# City of Albuquerque Stormwater Construction Site Inspection Report

ESC File No.	B18E028	Project Name:	Burger King		
NPDES Id. No.	NMR100463	Location:	2110 Carlisle Blvd. NE		
2/28/2022	Owner	Contractor			
Operator	Auto Nation USA	Rycon Construction Inc			
Contact name & title	Fred Moss	Michael Burns			
e-mail	<a href="mailto:mossf@autonation.com">mossf@autonation.com</a>	<a href="mailto:mburns@ryconinc.com">mburns@ryconinc.com</a>			
Contact Phone #	954-769-2303	263-6965			
COA Inspector	Doug Hughes	Start/End Time:	4pm		
Construction Phase:	Excavation/grading				
Type of Inspection:	<input checked="" type="checkbox"/> Regular	<input type="checkbox"/> Storm Event	<input type="checkbox"/> Past Storm Event >0.25"	<input type="checkbox"/> 311/Complaint	<input type="checkbox"/> Follow Up
Weather at time of inspection?		clear		Temperature: ~	60
Estimated date of last storm 0.25" or greater		2/2/2022

SWPPP POSTING REQUIREMENTS:

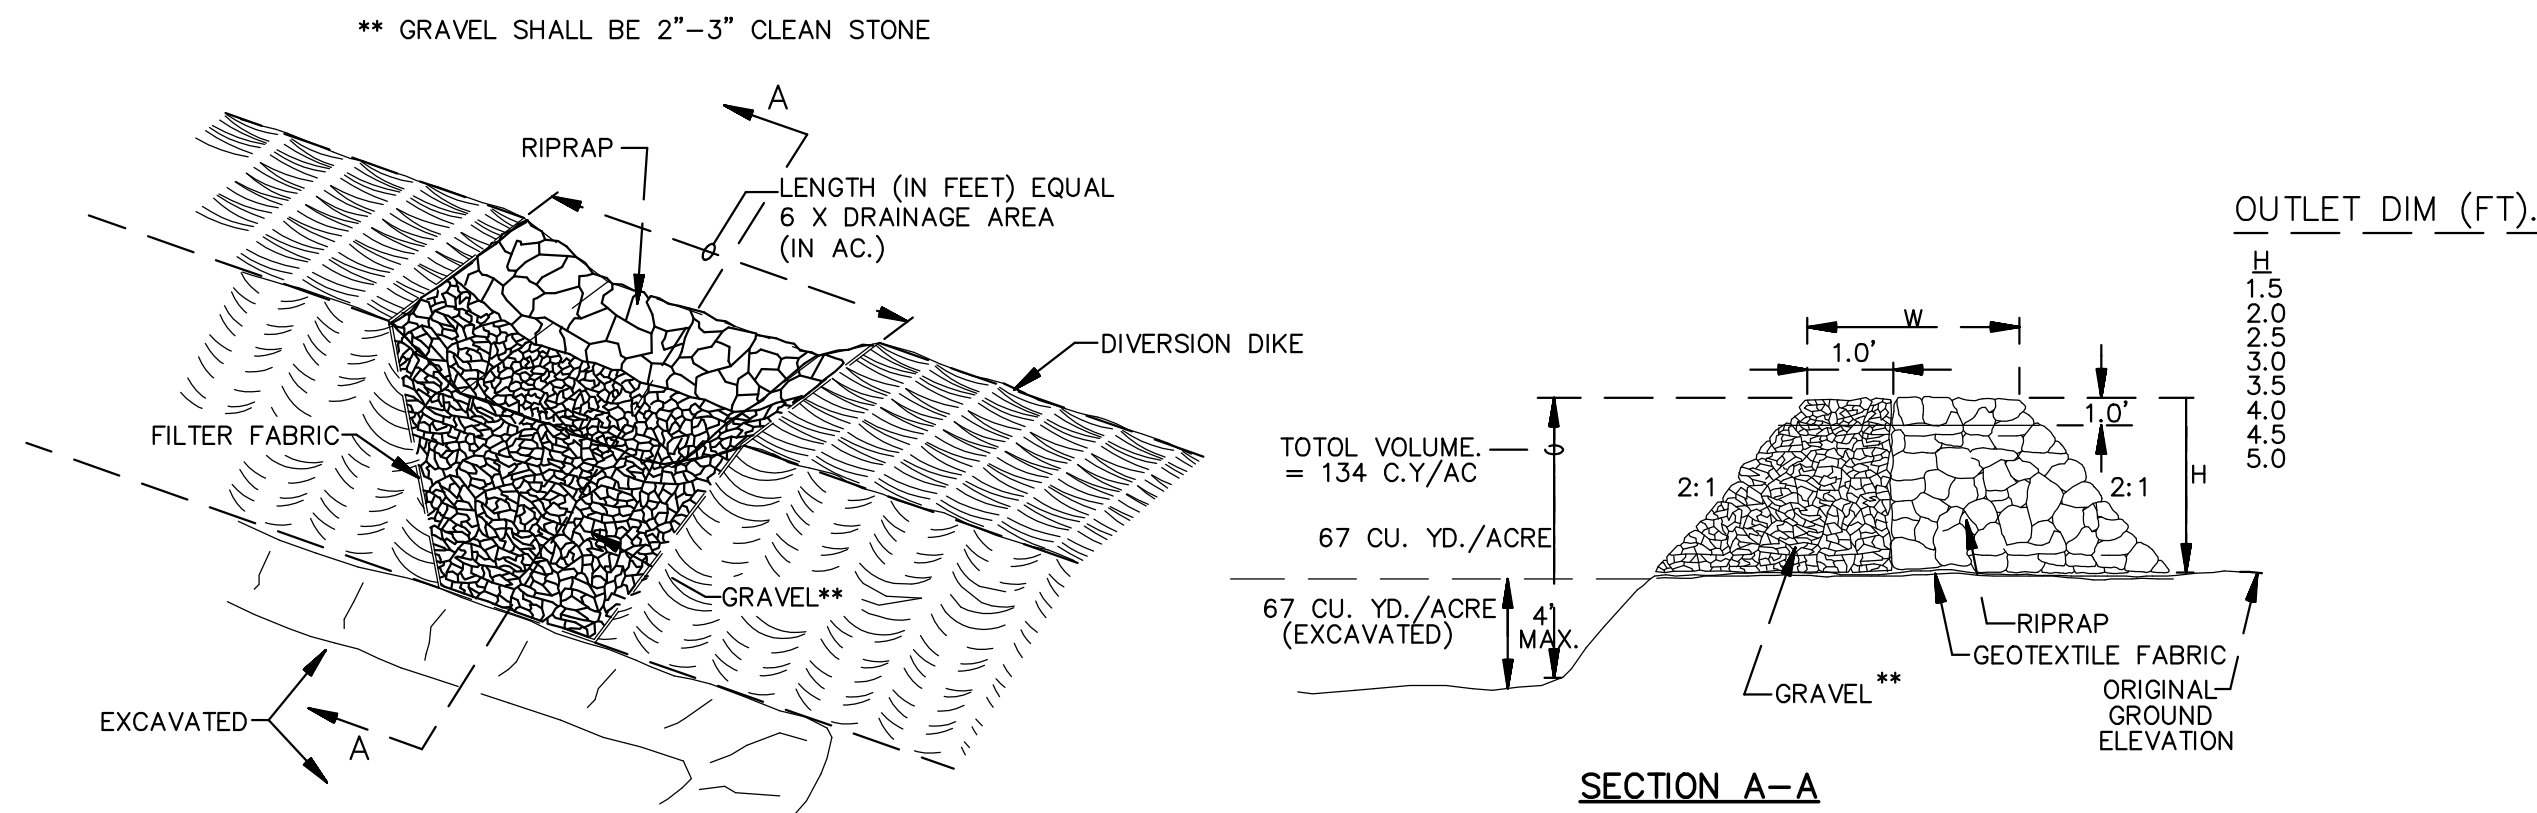
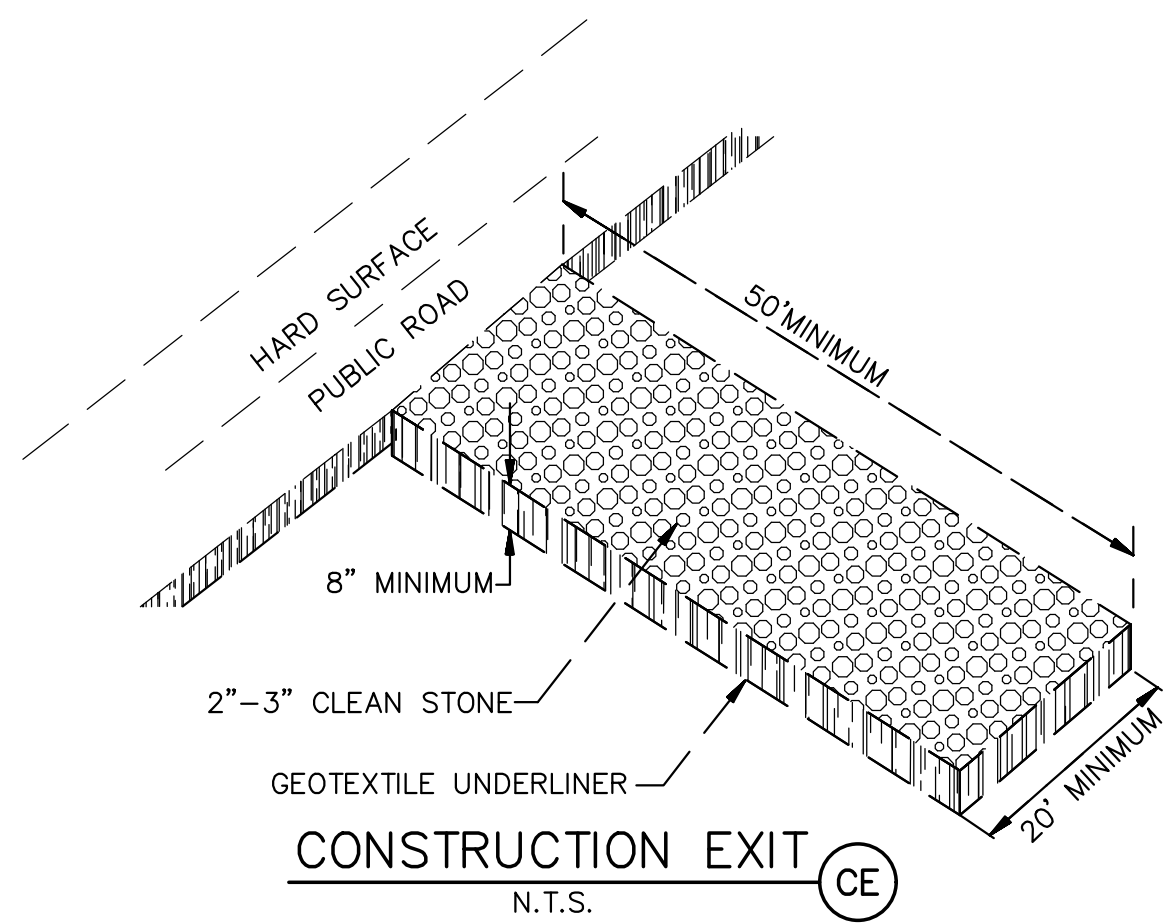
Notes:	
Foundation footings excavated and steel in the trench, but no washout container on site.	
The area of land disturbing activities has been increased to include the two lots adjacent to San Pedro, so the SWPPP map and NOI need to be revised, to update the SWPPP.
